Engineers comments in respect to surface water drainage:

APPLICATION NO: LY/9/17/PL

Site Address: Roseland The Causeway ARUNDEL BN18 9JL

Description of Works: Demolition of the existing building & cessation of mixed commercial/residential use & redevelopment of the site with a new two storey building, comprising 4 no. residential flats - This is a Departure from the Development Plan

SITE PLAN

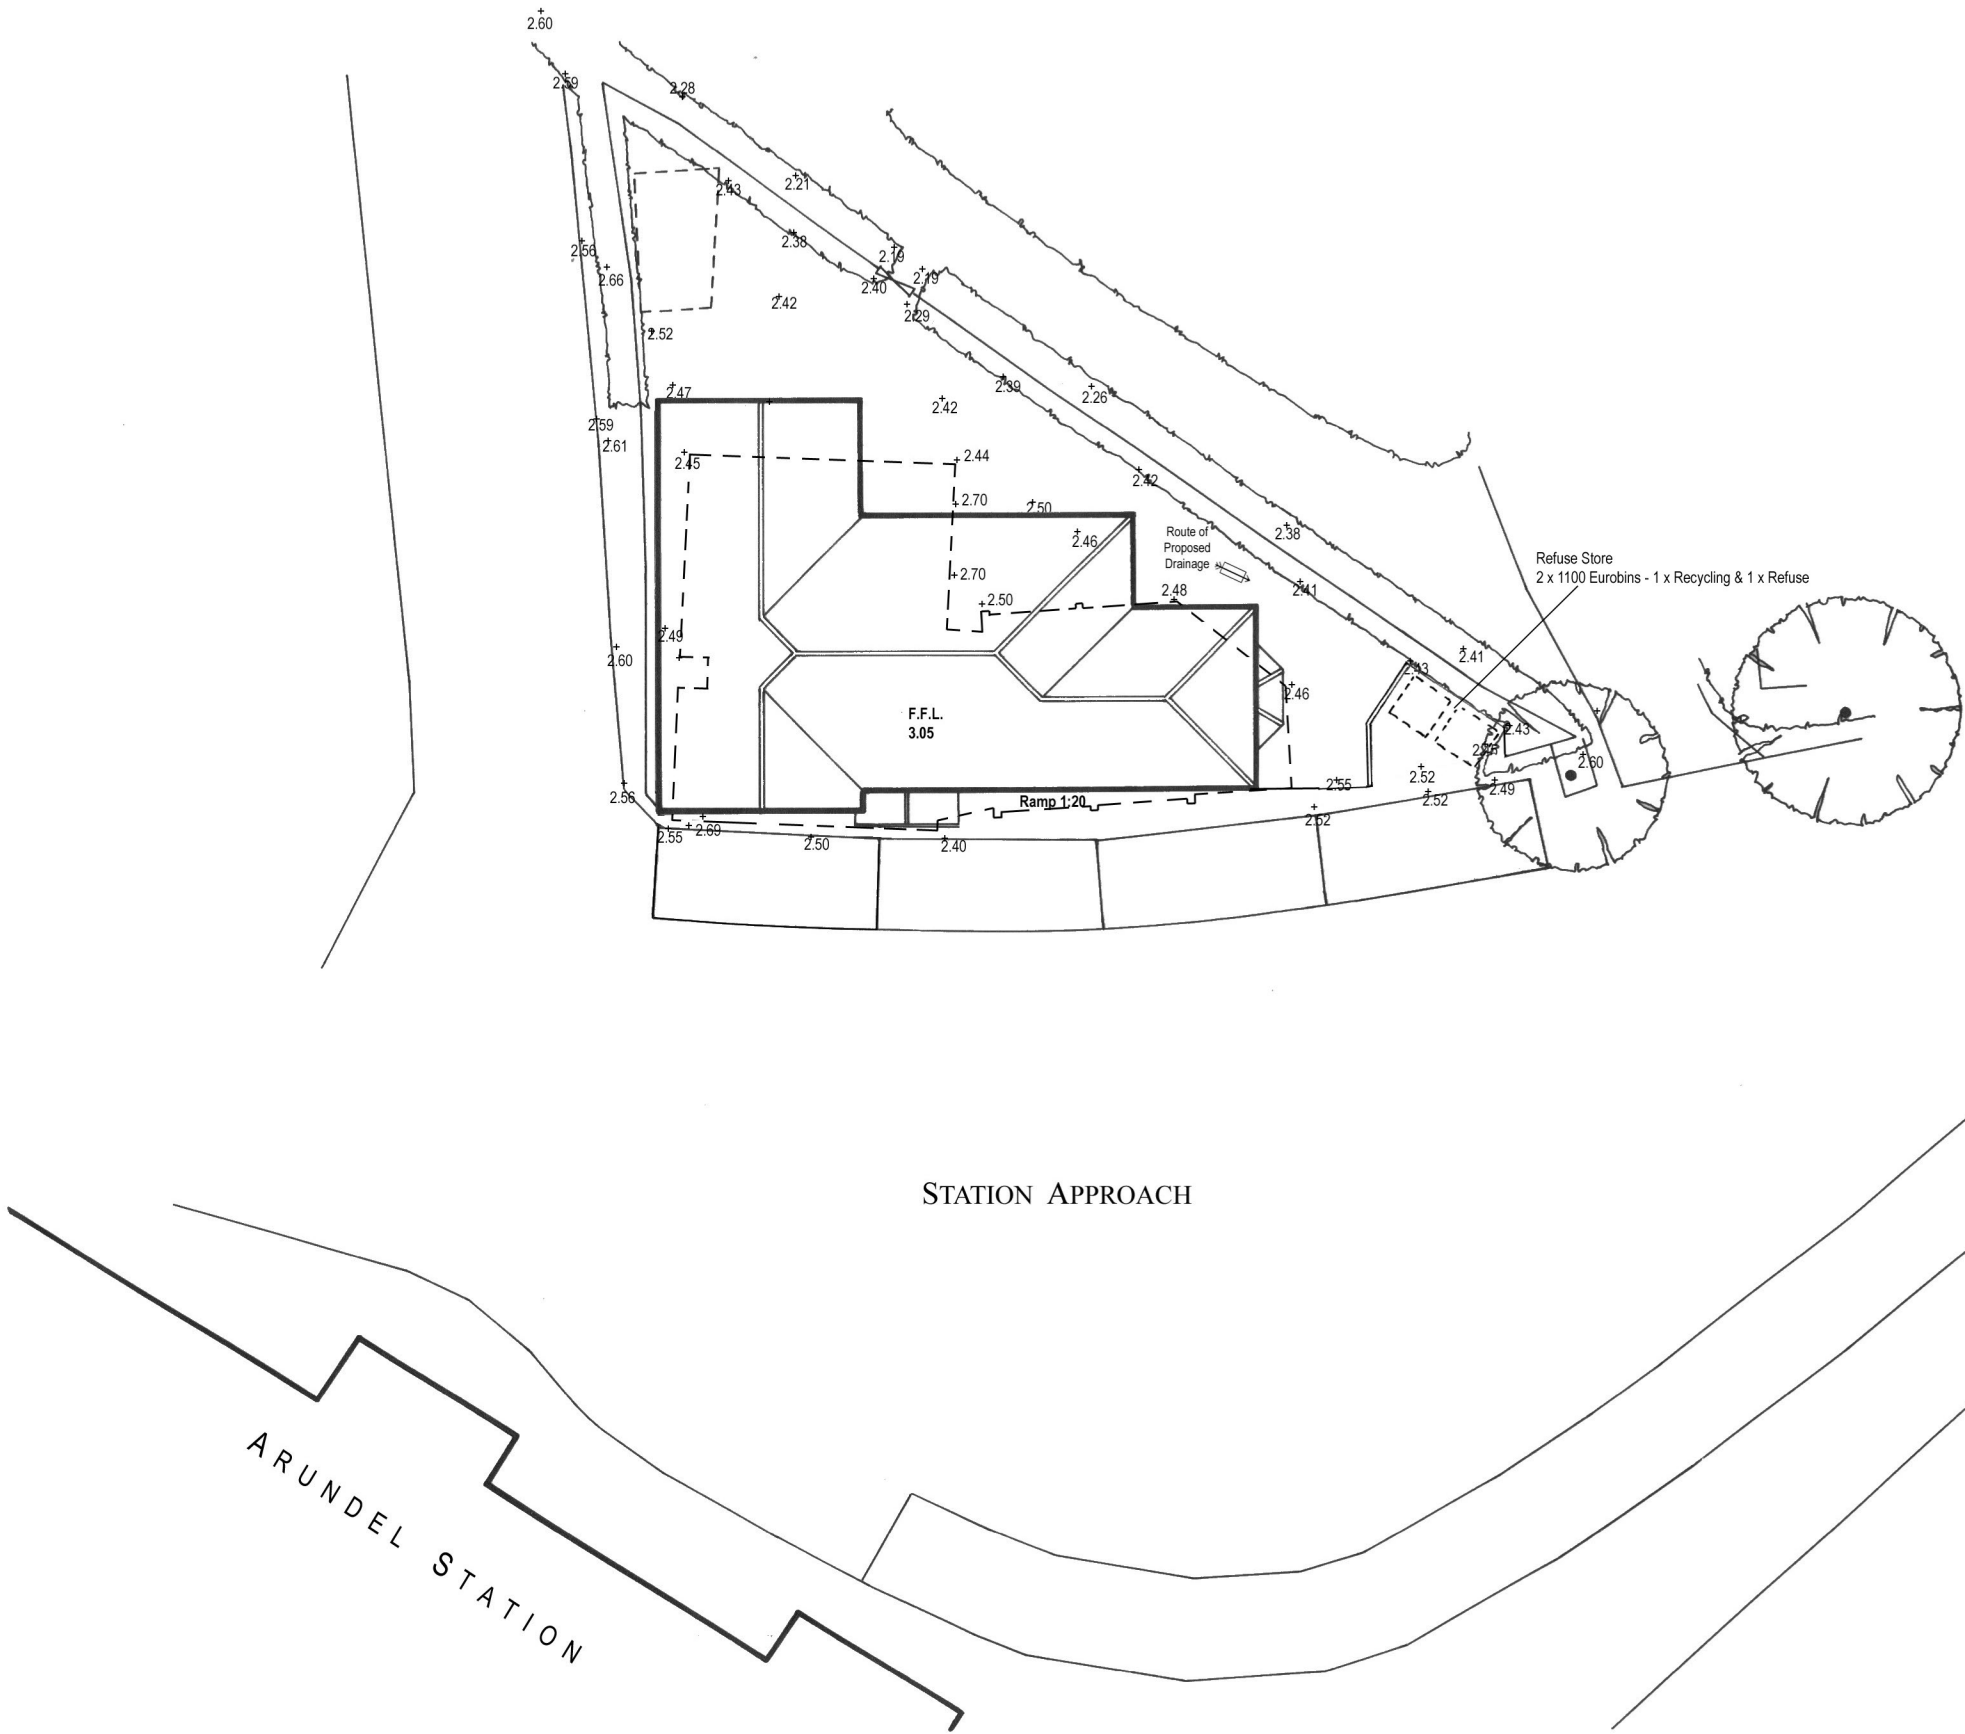
A culverted watercourse may cross the application site. If this is confirmed, then there could be significant implications in respect to any proposed redevelopment of the site. The applicant is urged to investigate this matter further, and discuss with ADC Engineers/Environment Agency (as the internal drainage board).

Infiltration must first be investigated for surface water disposal, although available areas for soakaways may be limited.

Any SuDS or soakaway design must include adequate groundwater monitoring data to determine the highest winter groundwater table in support of the design. The applicant is advised to discuss this with the Council's Engineers, who already hold information in this respect. Supplementary guidance notes are also enclosed for information.
